Your Ref: OWPC15705
Our Ref: LU/280/17/PL 05-09-2017
Please ask for:
Mr D Easton

Conversion of existing building to form 5 No. dwellings with associated cycle & refuse stores, parking & landscaping with dormers to north & south elevations.

General Henrys 31 Horsham Road Littlehampton

Proposed Conversion Elevations

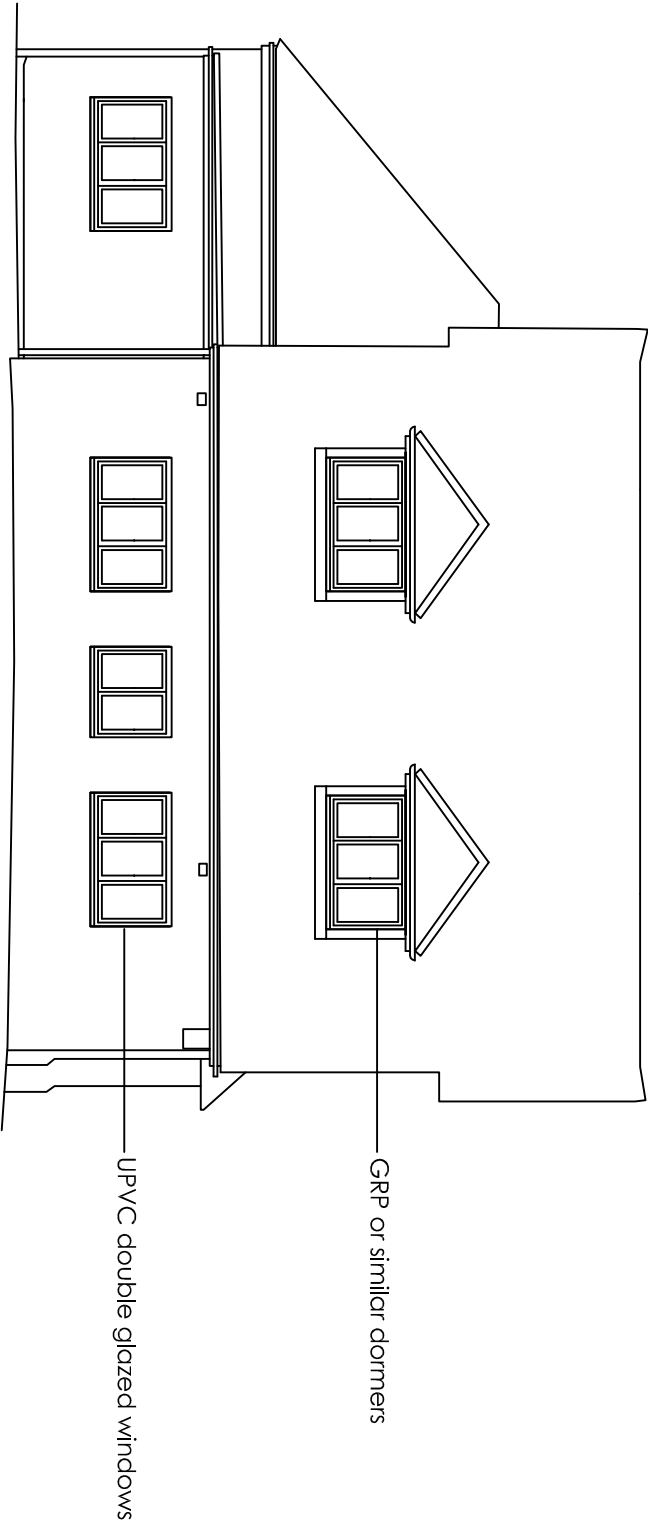
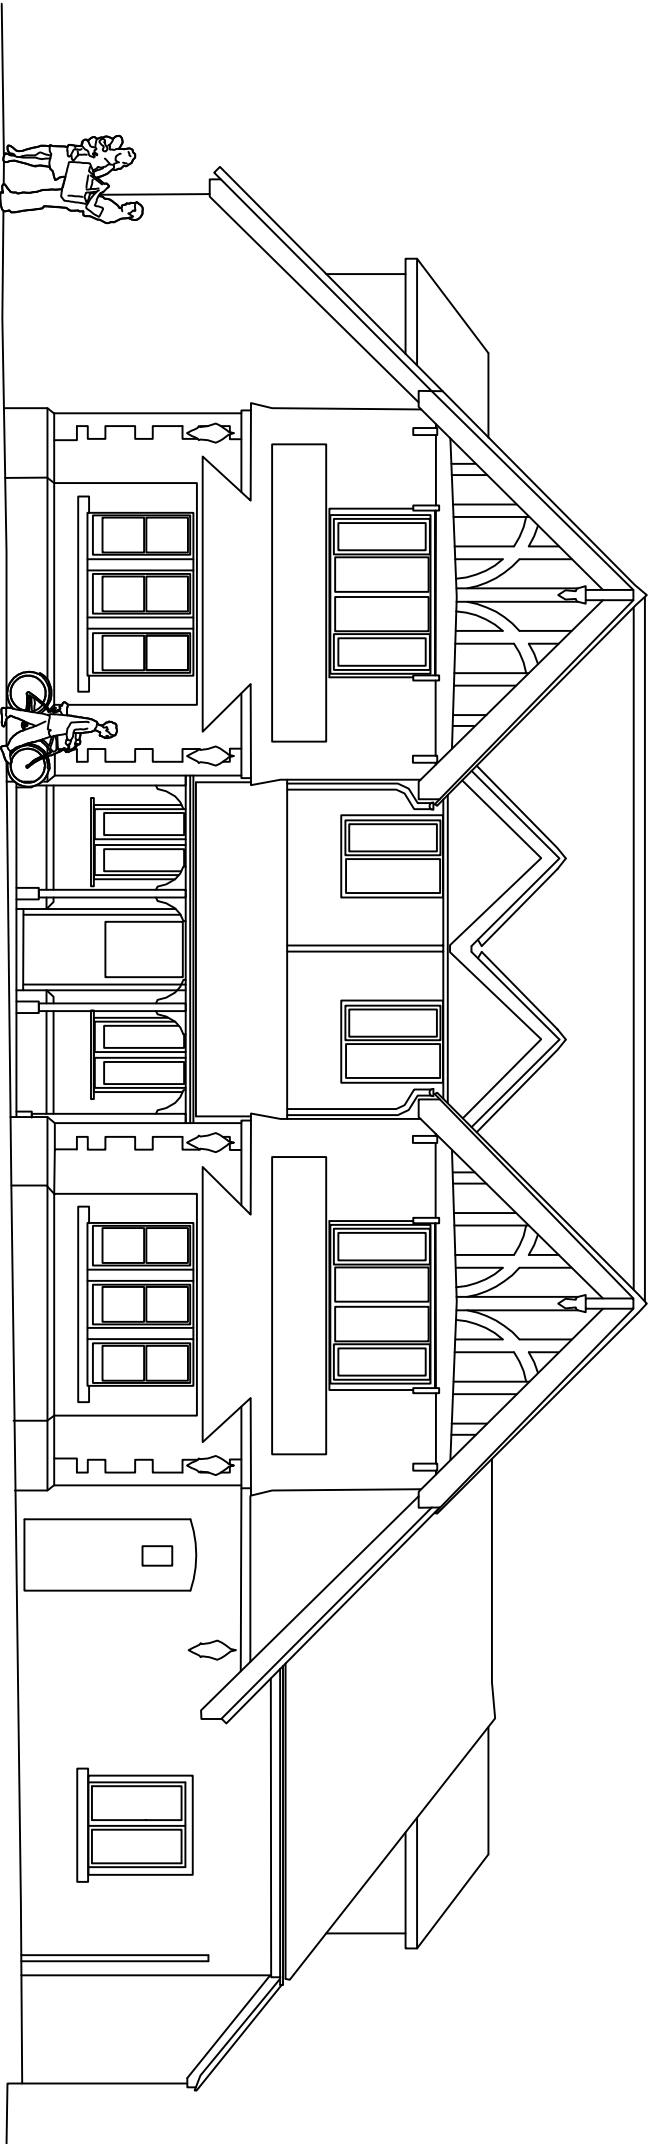
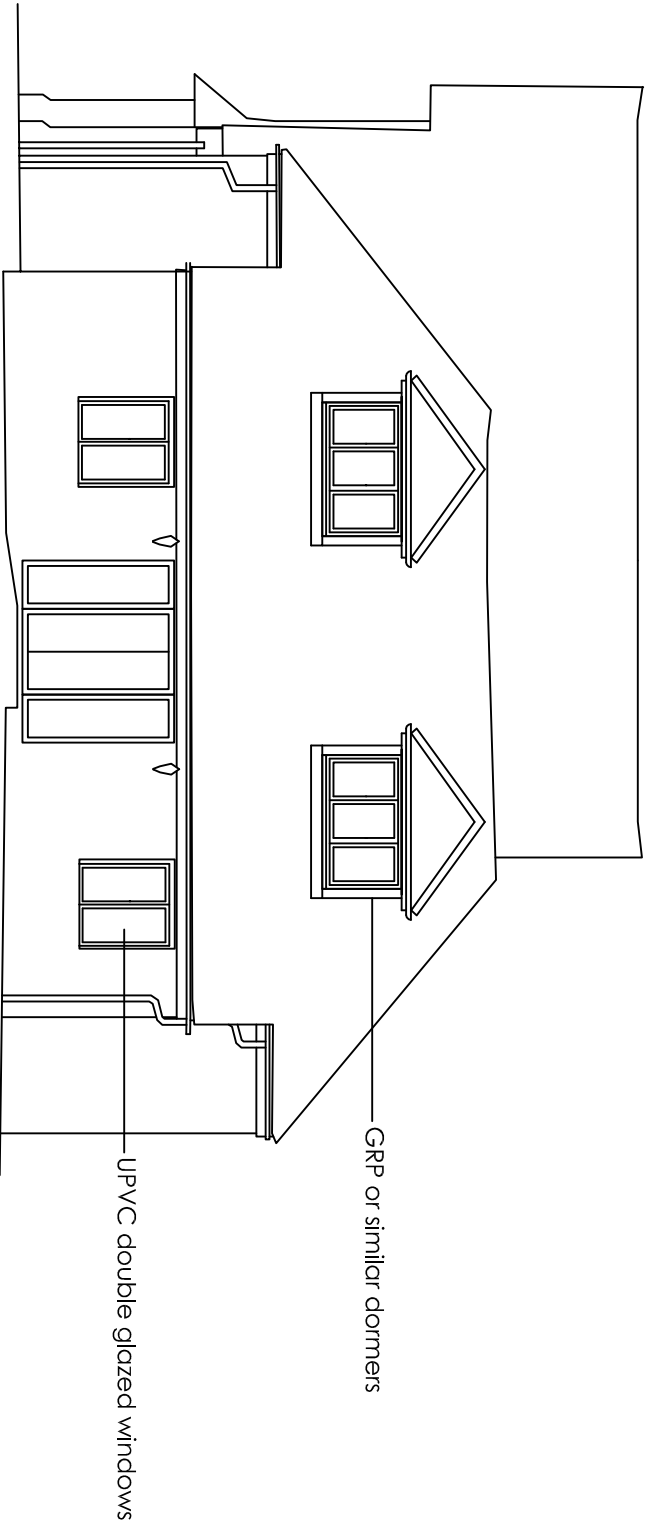
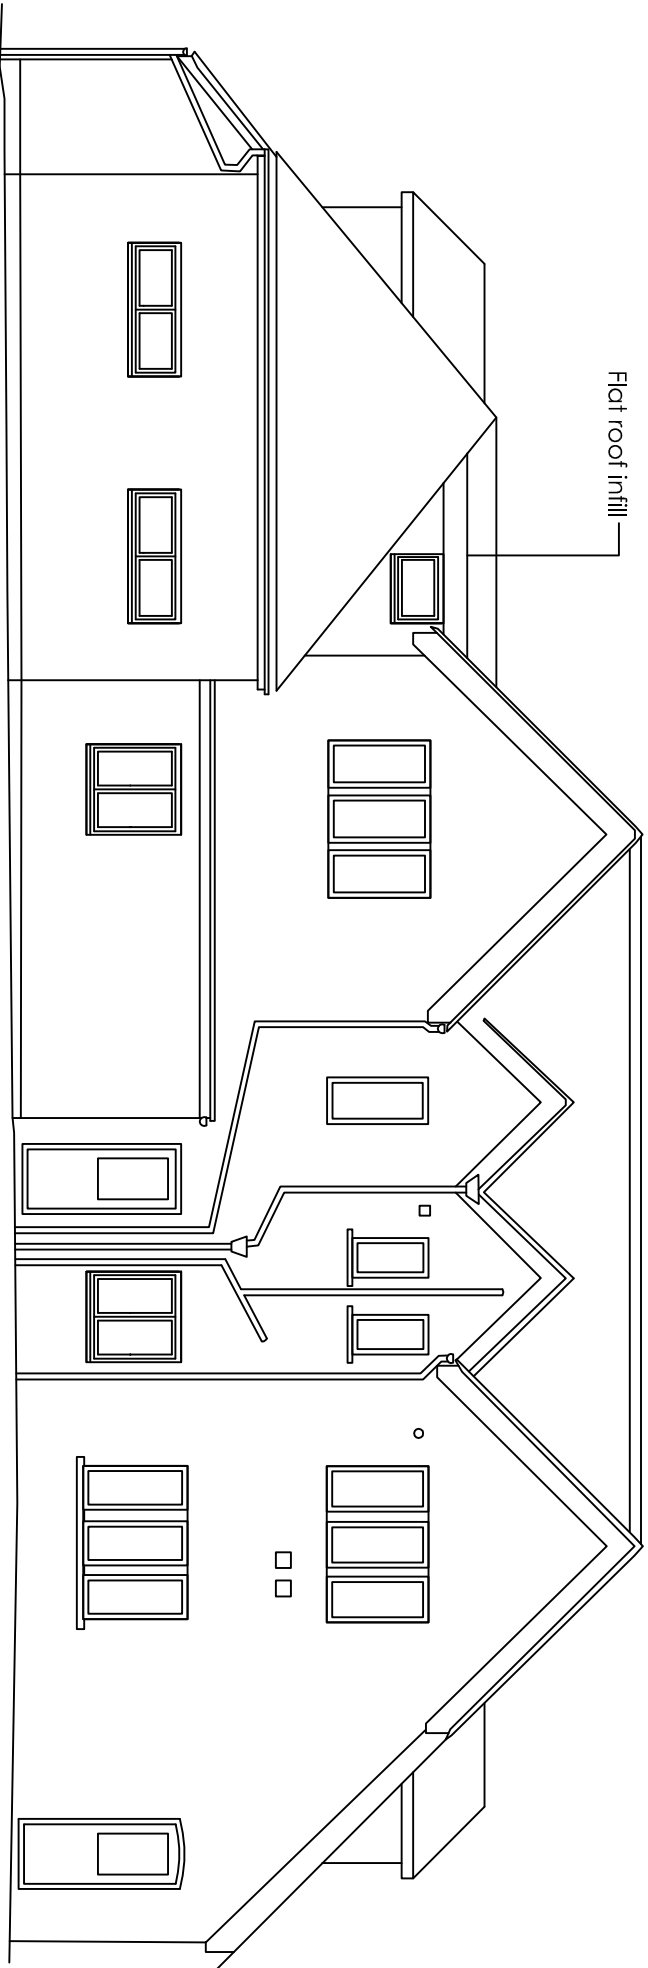
I wish to register an objection to the south elevation of General Henry's, both of the proposed dormers on this elevation look straight into my kitchen, front room, rear bedroom and garden. This I feel is major intrusion into my privacy.
